# **The Northwood Action Group Inc**

### **Subject: Objection to Redevelopment of Greenwich Hospital (Concept Proposal) SSD 17\_8699**

B CROSS SECTION - HOSPITAL
1:250 1:500 @ A3

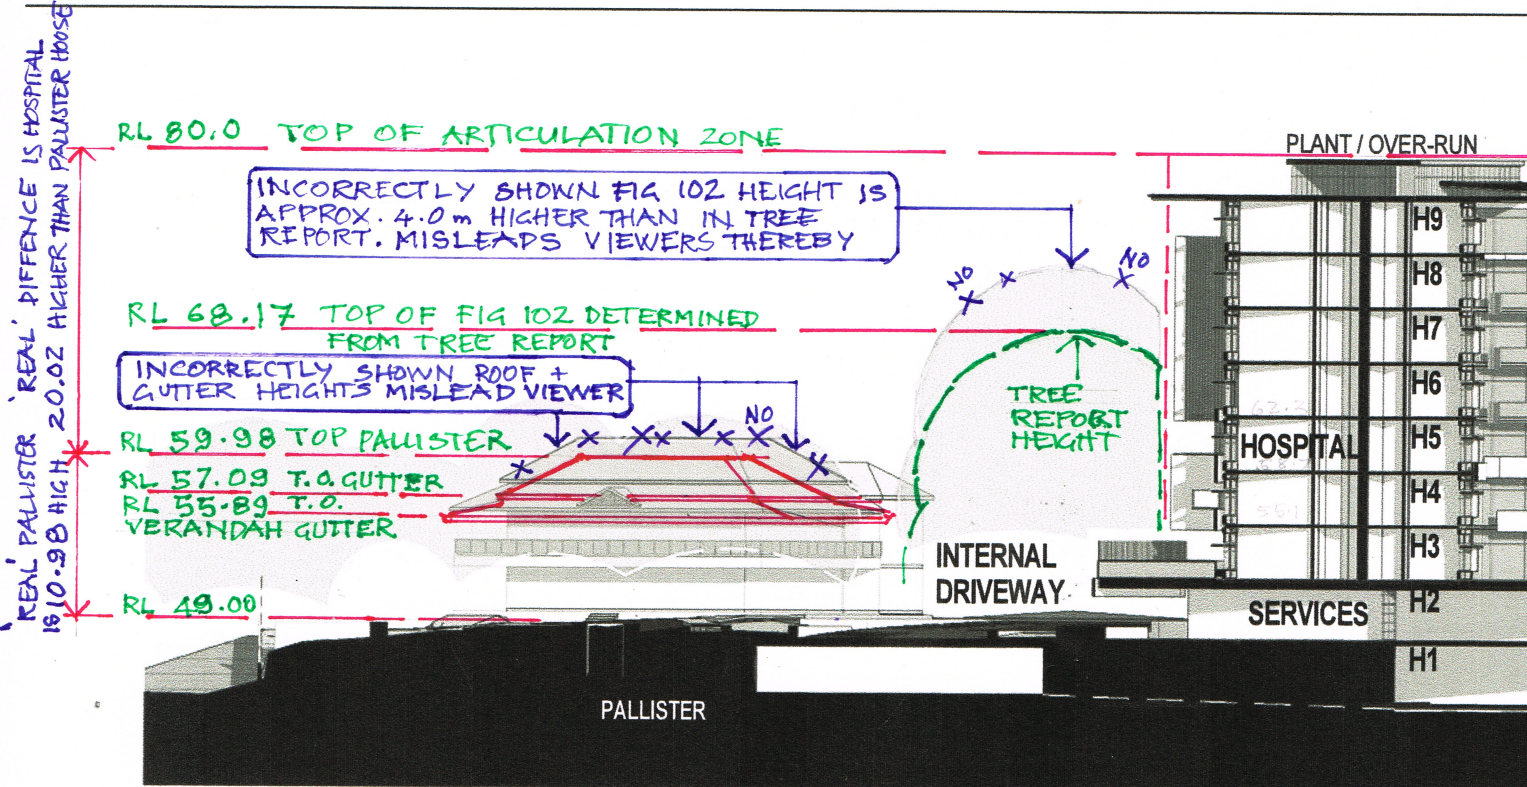
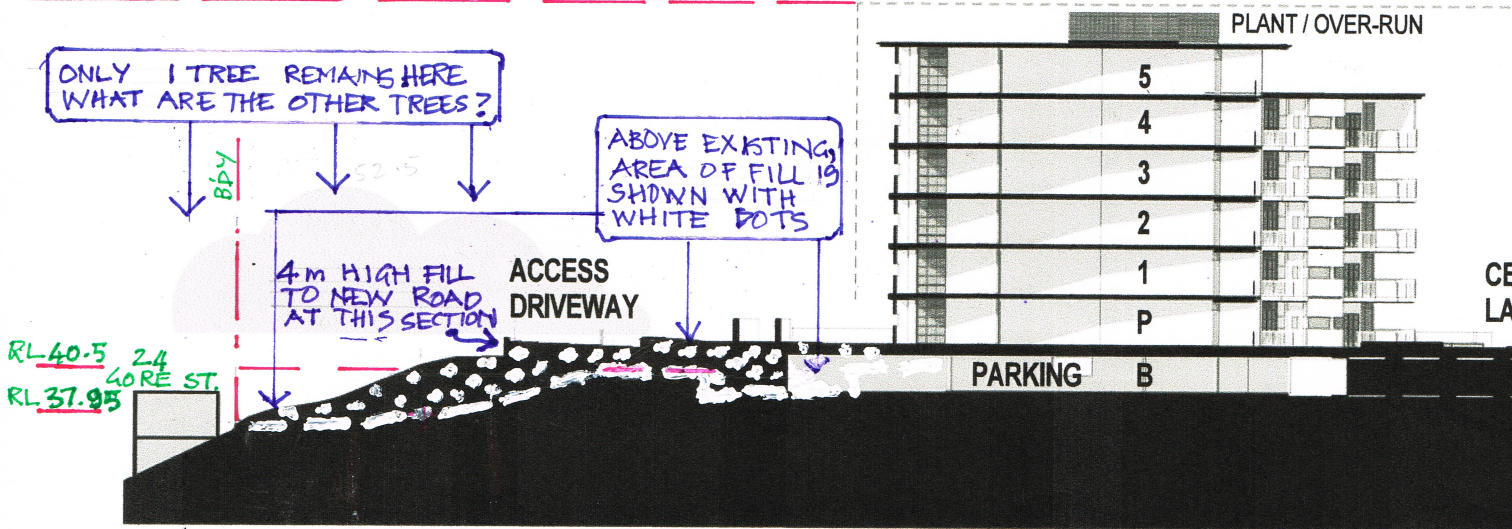
Misleading Error: In drawings’ depiction of Height of Pallister House and Fig Tree 102: the drawings are in error in the drawn height. Pallister’s slate rooftop is RL59.98, forming a top-ridge-rectangle around a sunken inner roof (evidenced on any aerial view), and the attached brick building to the west has a ridge of RL60.65, by survey. Elevation/section Drawings, however, show the Pallister rooftop about 2.15m higher than is its maximum height, obtained by the survey, while the RL60.65 ridgeline to the west is accurately depicted, in its correct height, but is shown lower than the “wrongly inflated” height of Pallister House. Meanwhile top of Fig Tree 102, is depicted having top at RL 72.5, which is 3.3 m higher than it is by Survey [which shows it growing from RL49.17 level, and being 20 m high,  $(49.17 + 20 = 69.17)$ ], or 4.3 m higher than it is if the Arborist’s height of 19 m is used.

The answer to the latter must be Yes, as certainly most viewers of the drawings would have accepted the Fig Tree 102 height at what (and where) it is shown, and the Pallister House rooftop as being realistically depicted on say Dwg S.04, but it misleads with a false impression of new building height relative to Pallister and the Fig 102, which are given inflated, incorrect prominence.
